12 February 2024

your ref 2023/93667

Application 2023/93667 Storthes Hall Lane – demolition of buildings and erection of residential development (up to 261 dwellings)

Client	Utique				
Project	1826 Residential Development at Storthes Hall, Kirkburton				
File	Tree Retention Plan				
Drawn By	Rev.	Scale	Drawn	Checked	Date
1826-S1-05	-	1:1000@A1	AK	JP	11/23

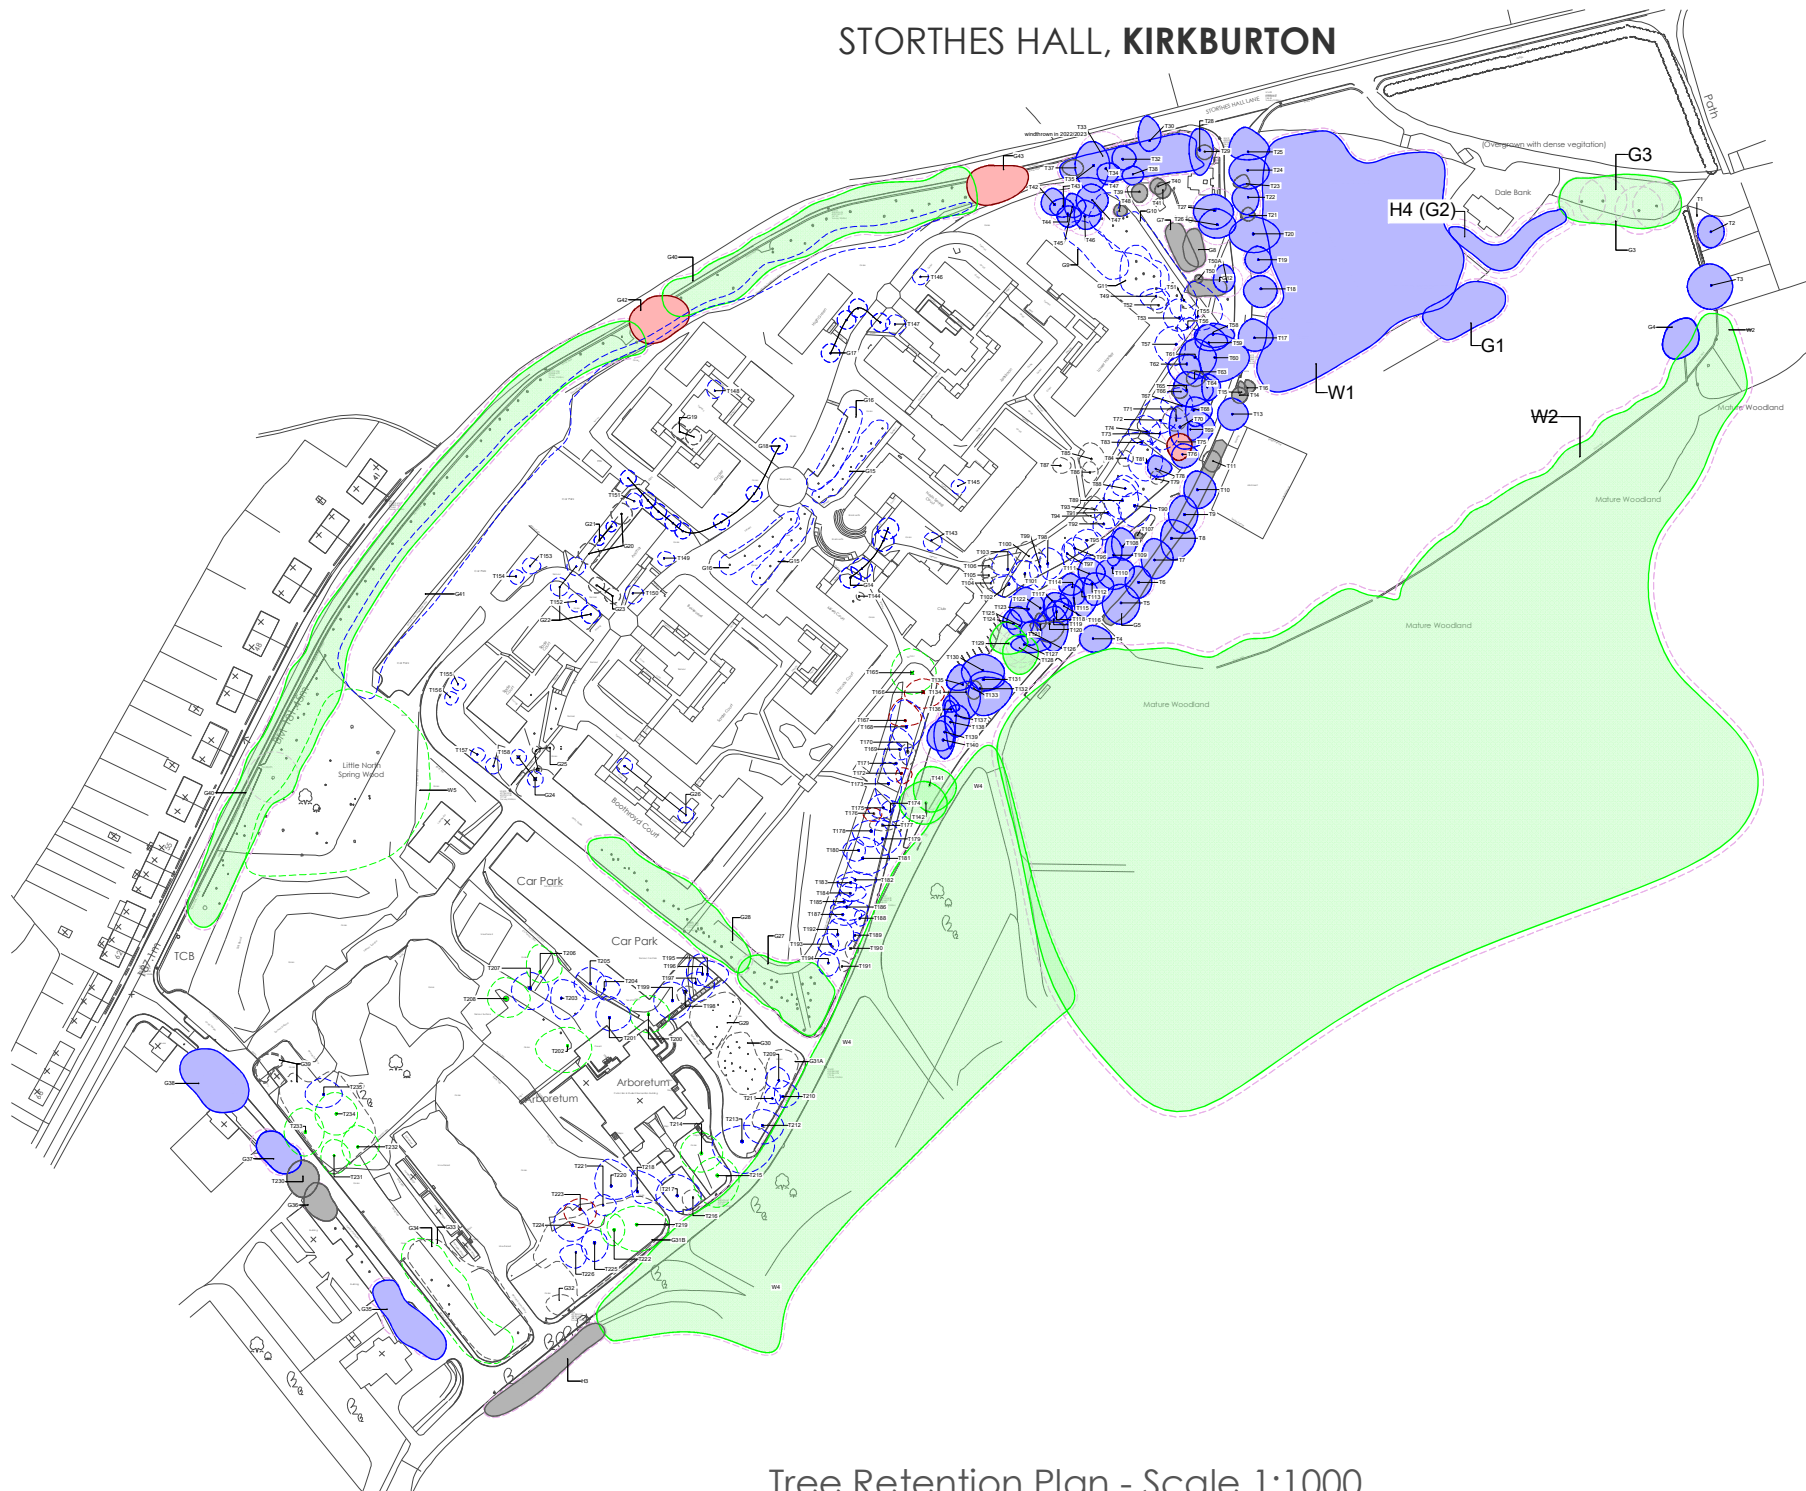
The development proposal threatens the destruction of the wood and the loss of all the benefits it provides.

The proposed development would also result in the significant loss of other protected trees across the site, most notably those covered by Tree Preservation Orders 17/89/a6 and 17/89/a8 which were retained through the development of the student village.

LOCATION PLAN - 1826-SI-01  
STORTHES HALL, KIRKBURTON  
UBRIQUE  
SCALE: 1:1250@A1 - JULY 2023

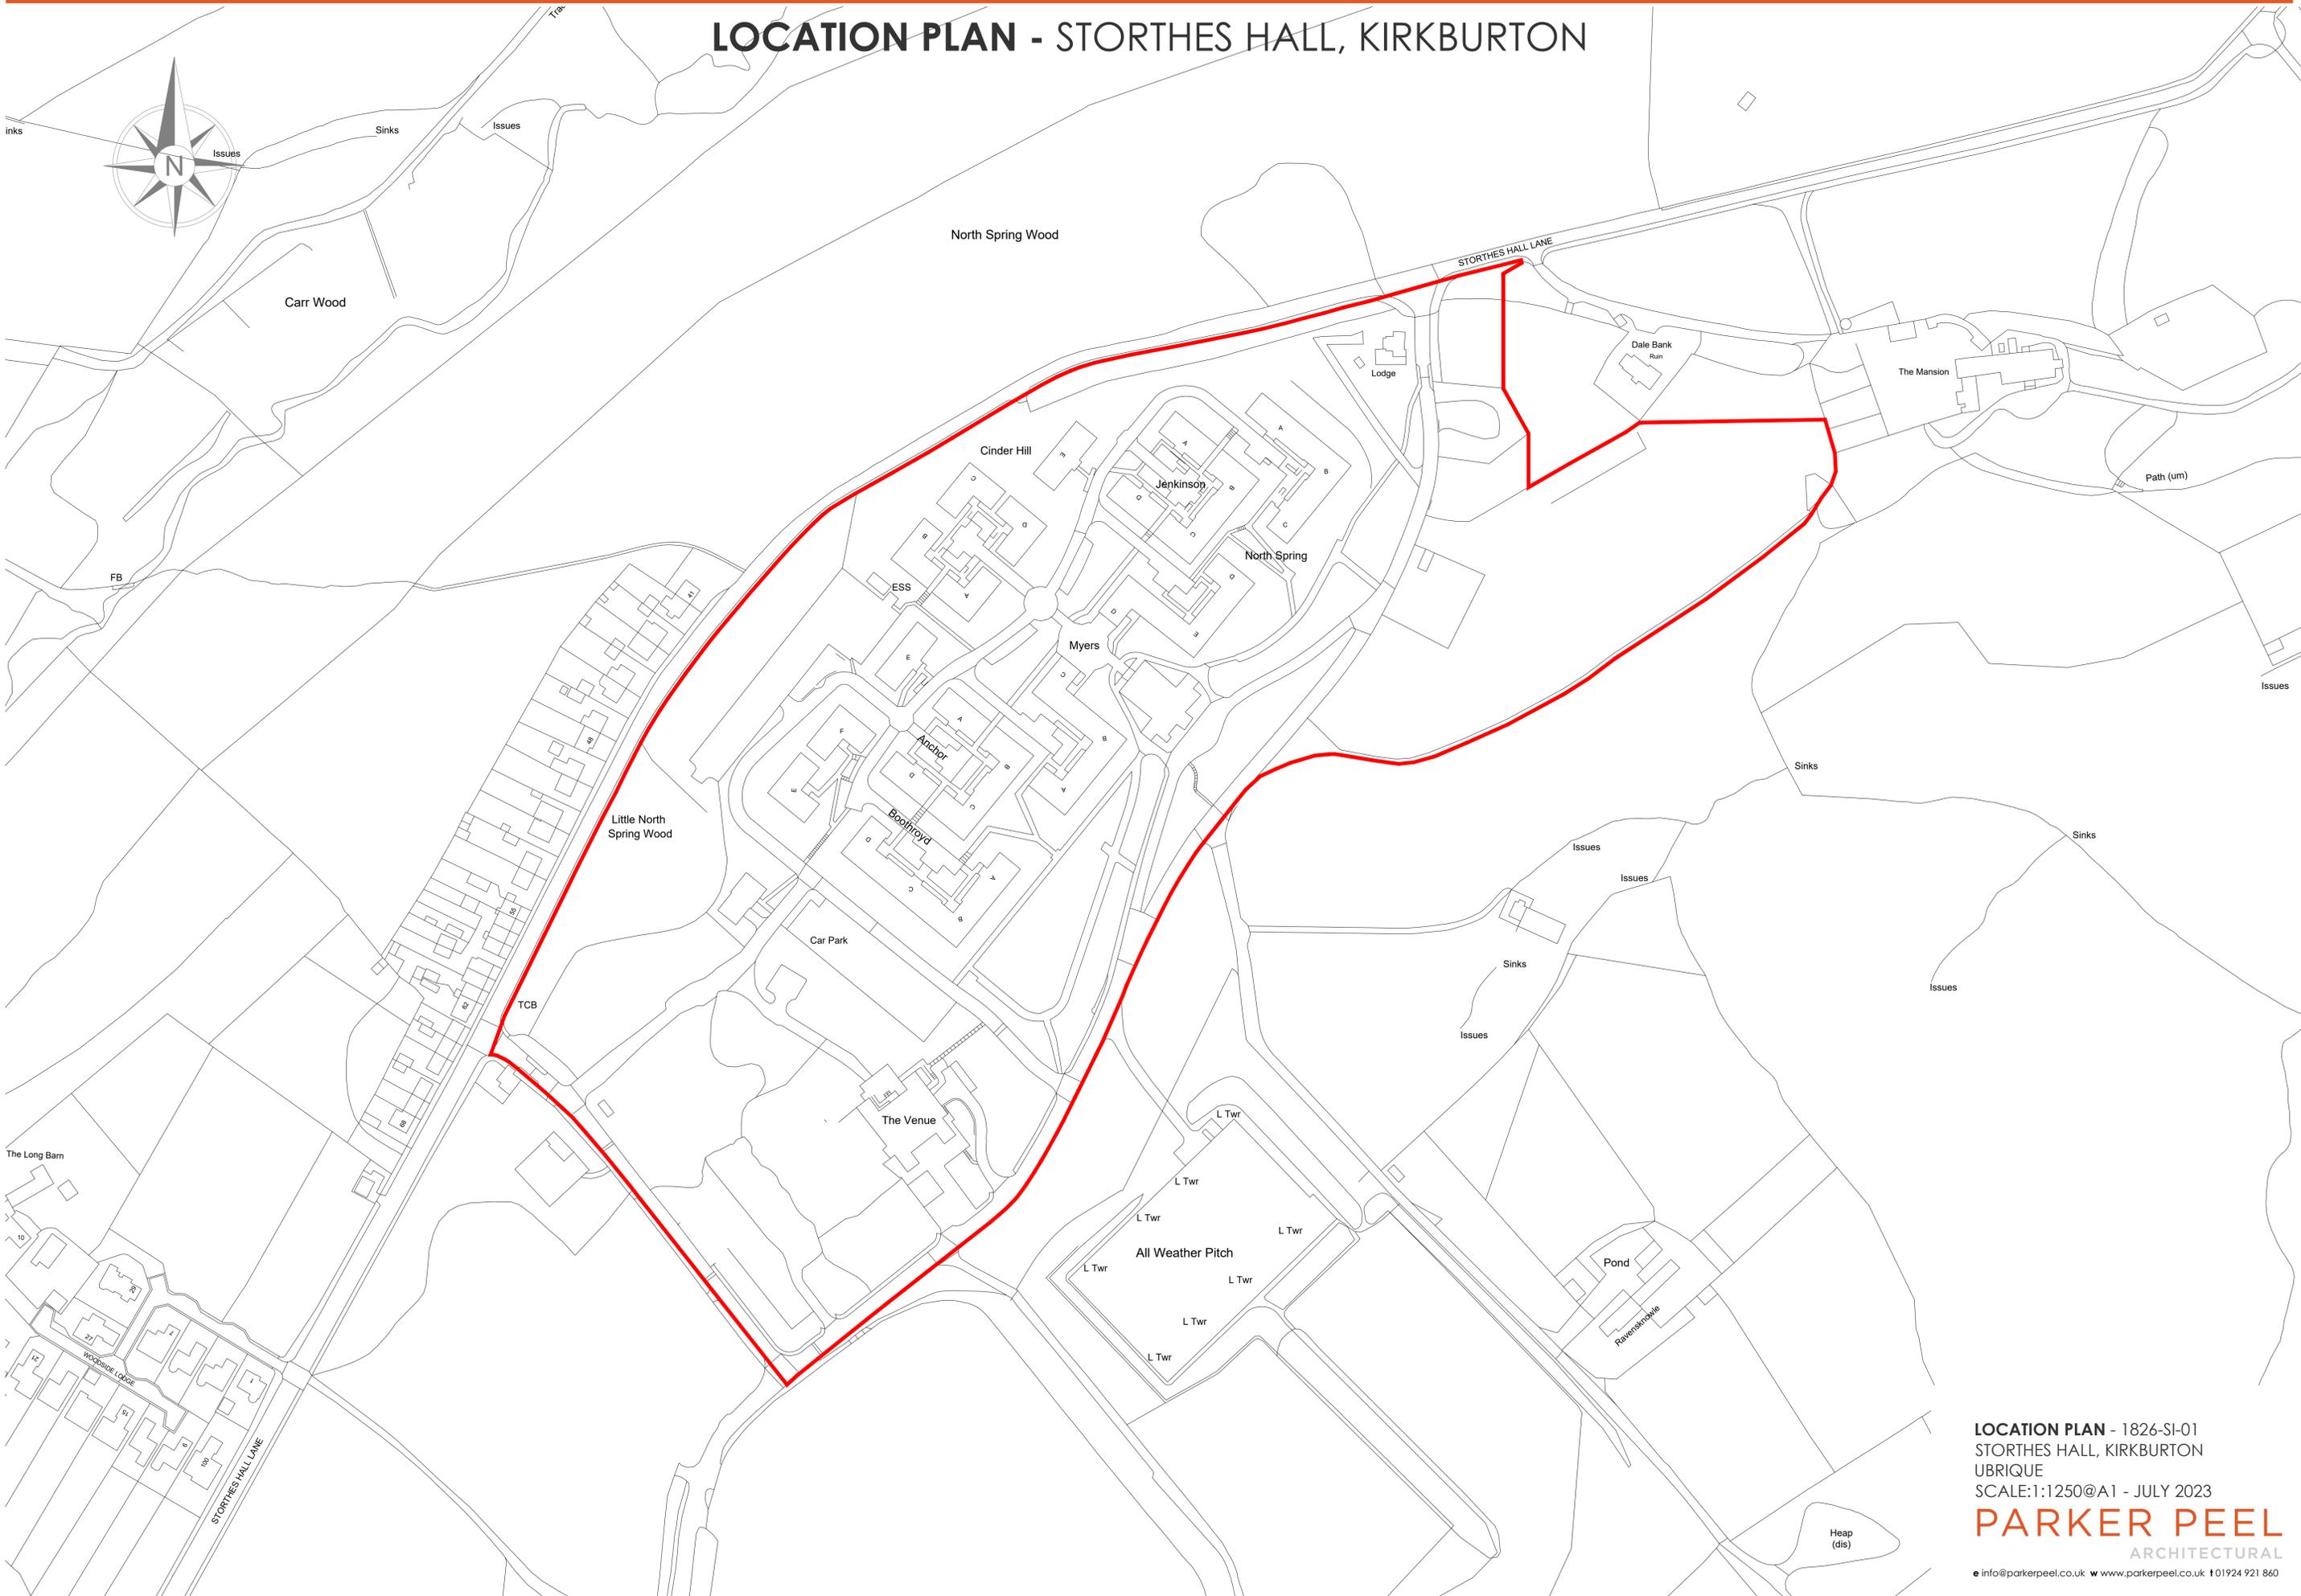
The application boundary extends beyond the Local Plan MDGB1 site, into neighbouring Green Belt/ greenfield land. This should not be treated as part of the MDGB1 site for development nor 'on-site' for the purposes of Biodiversity Net Gain.
